Our Ref: CW/JM/PLAN/21
Date: 5 January 2021

R/253/20/HH - Single storey annex building ancillary to main dwelling - 33 Knightscroft Avenue, Rustington

ANNEXE
PROPOSED EAST (SIDE) ELEVATION 1:100

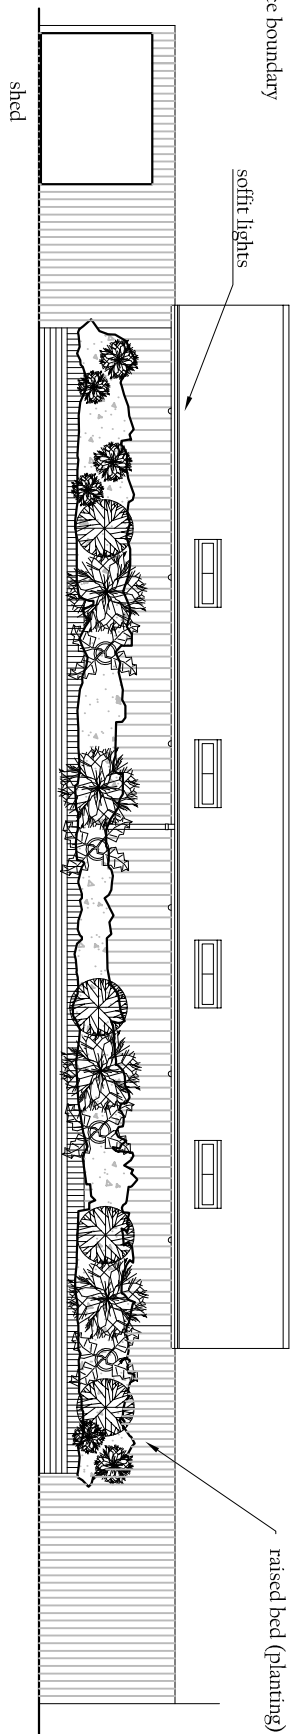
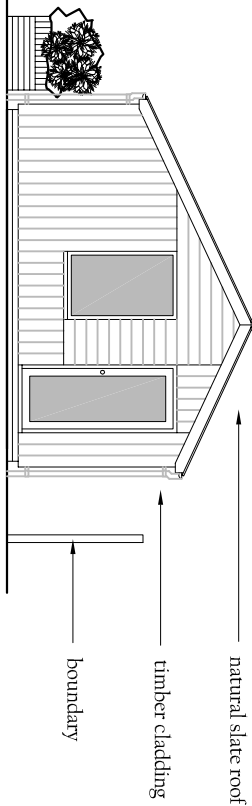
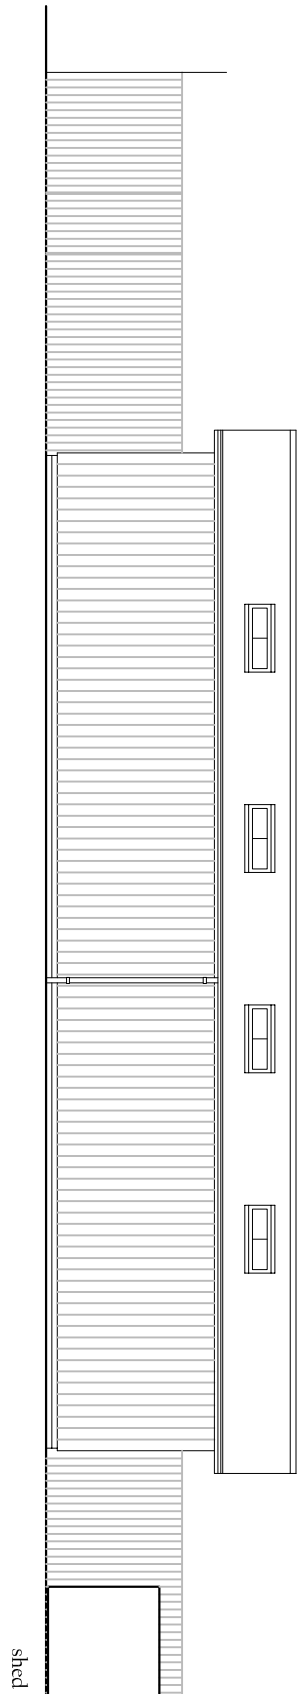
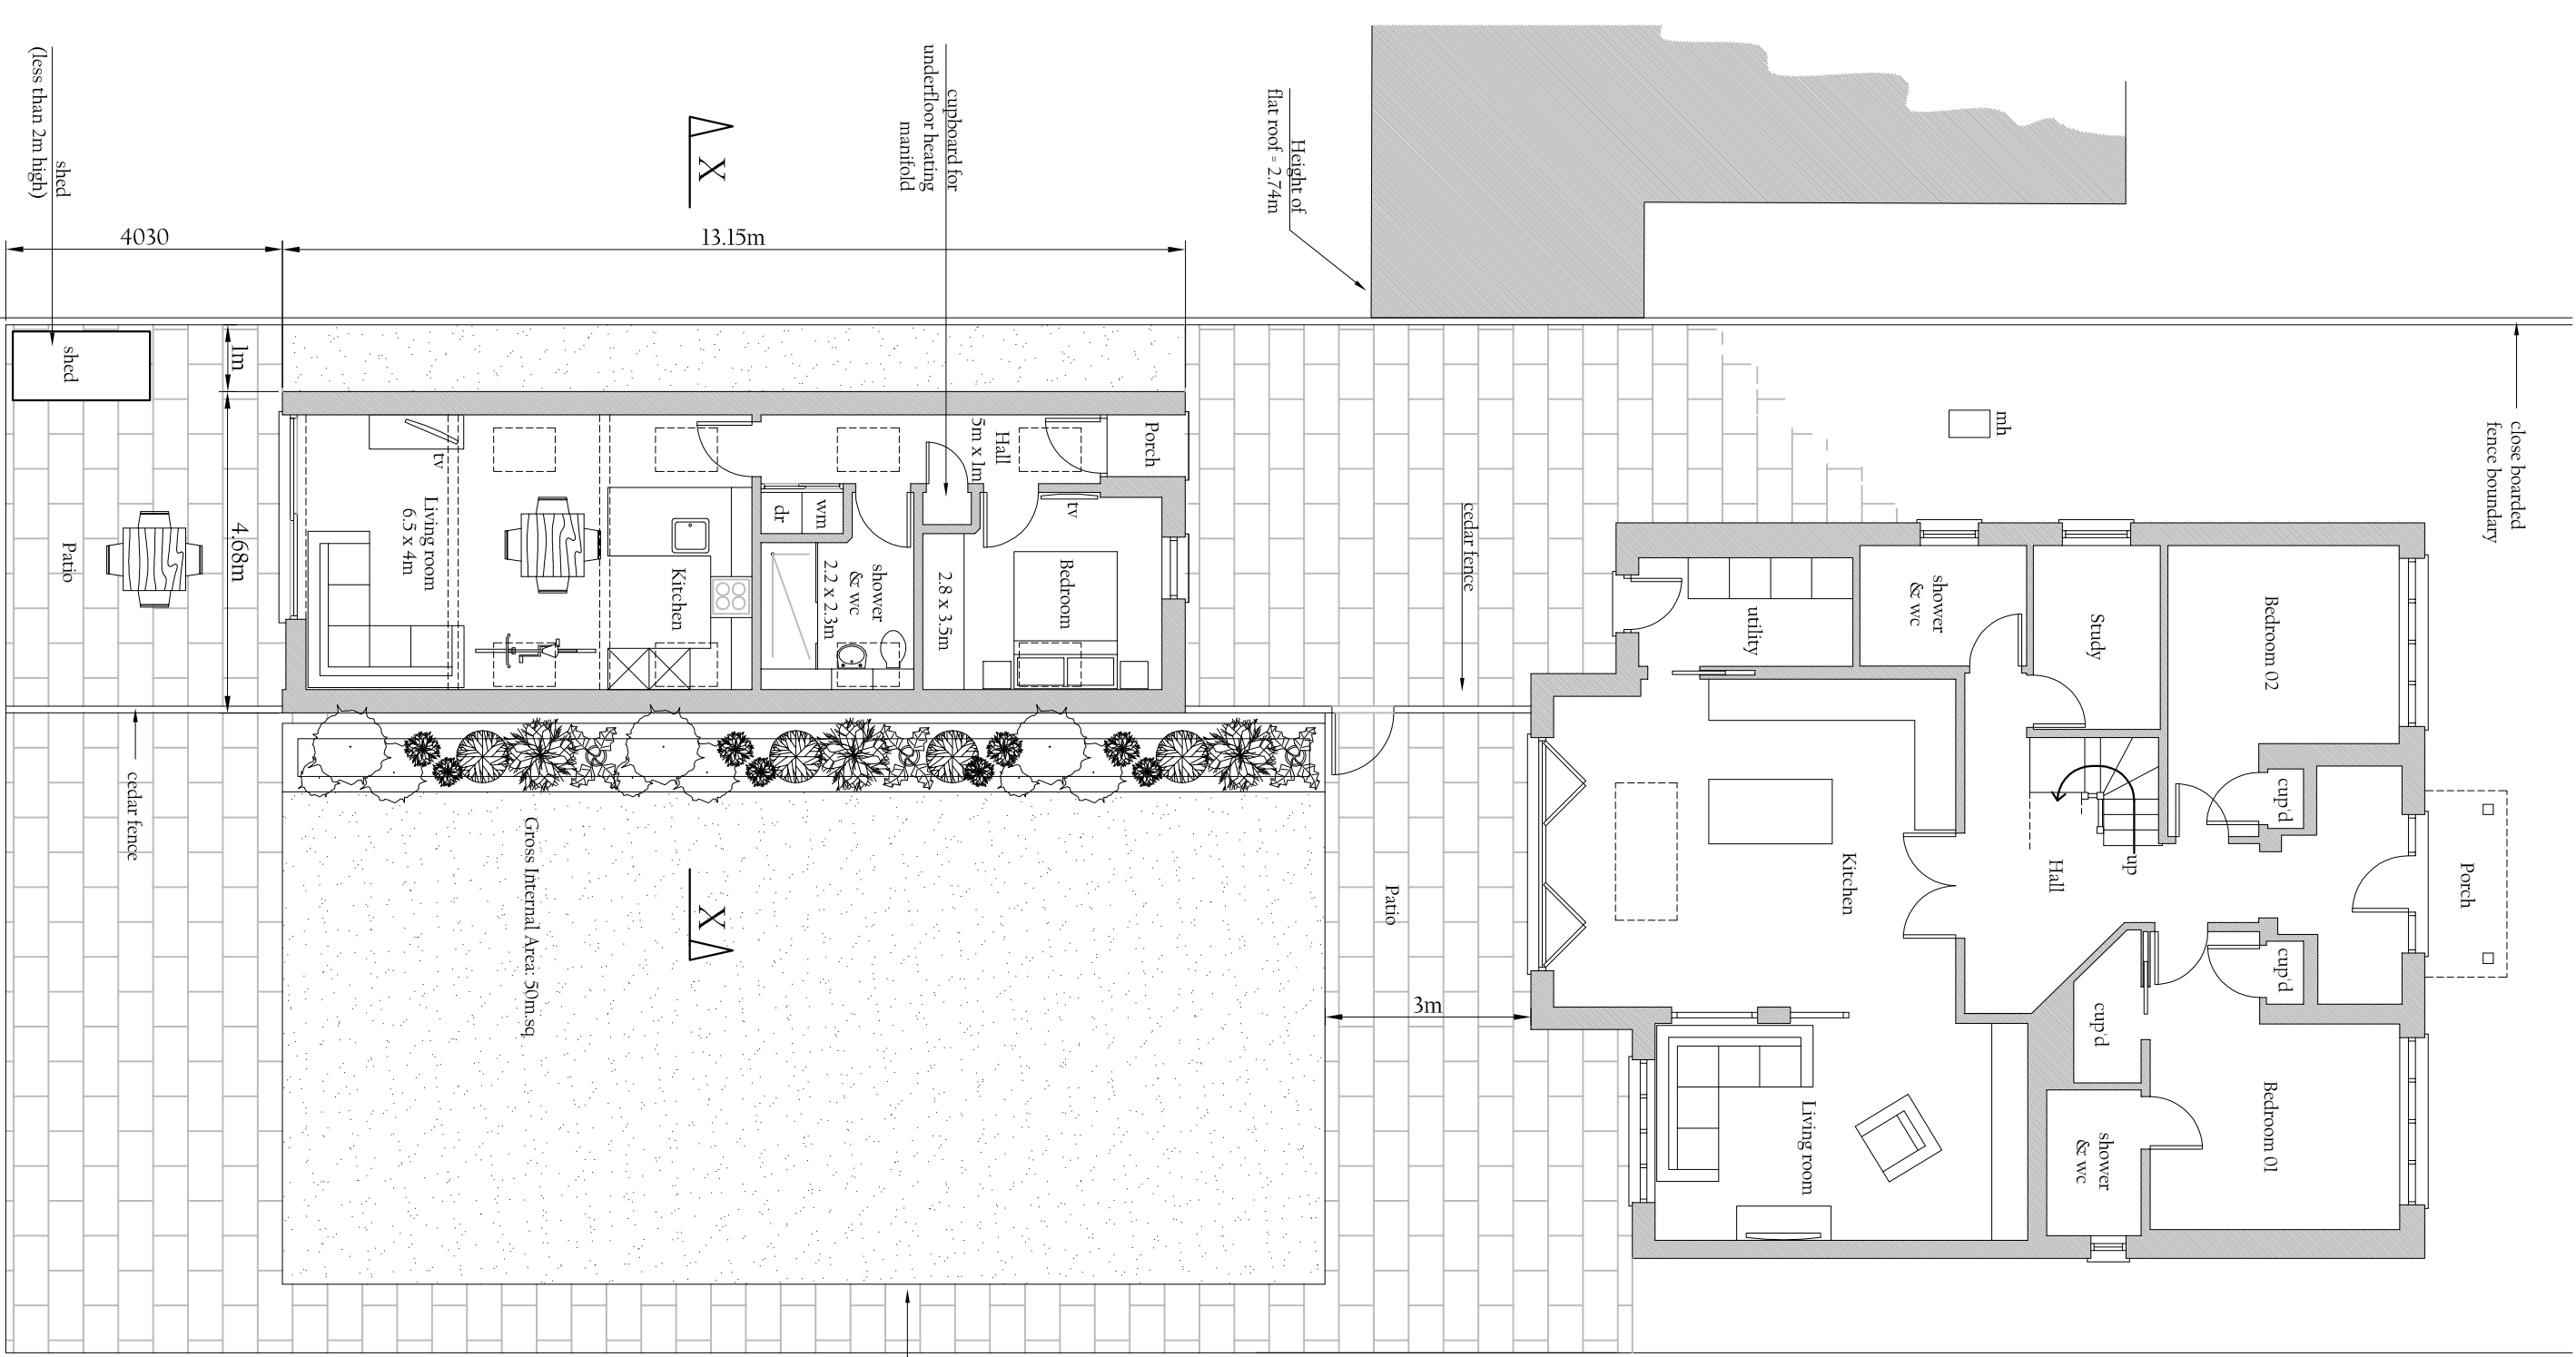
- (i) The proposal for a single storey annex of over 13 metres in length, would span almost one complete side of the back garden, and would most certainly represent an overbearing impact on the neighbouring property, namely No. 35 Knightscroft Avenue
- (ii) The proposal would have an adverse effect on the privacy, visual amenities and quiet enjoyment of the occupier/s of the aforementioned neighbouring property
- (iii) The proposal, by reason of its mass, would represent an over-development of the site
- (iv) The proposal for an additional living space could increase the vehicular movement in close proximity of No. 35 Knightscroft Avenue, and would also result in an increase in pedestrian footfall along the eastern boundary of that property.
- (v) The proposal would be in conflict with Policy 2 of the Rustington Neighbourhood Plan (mass and overbearing impact).
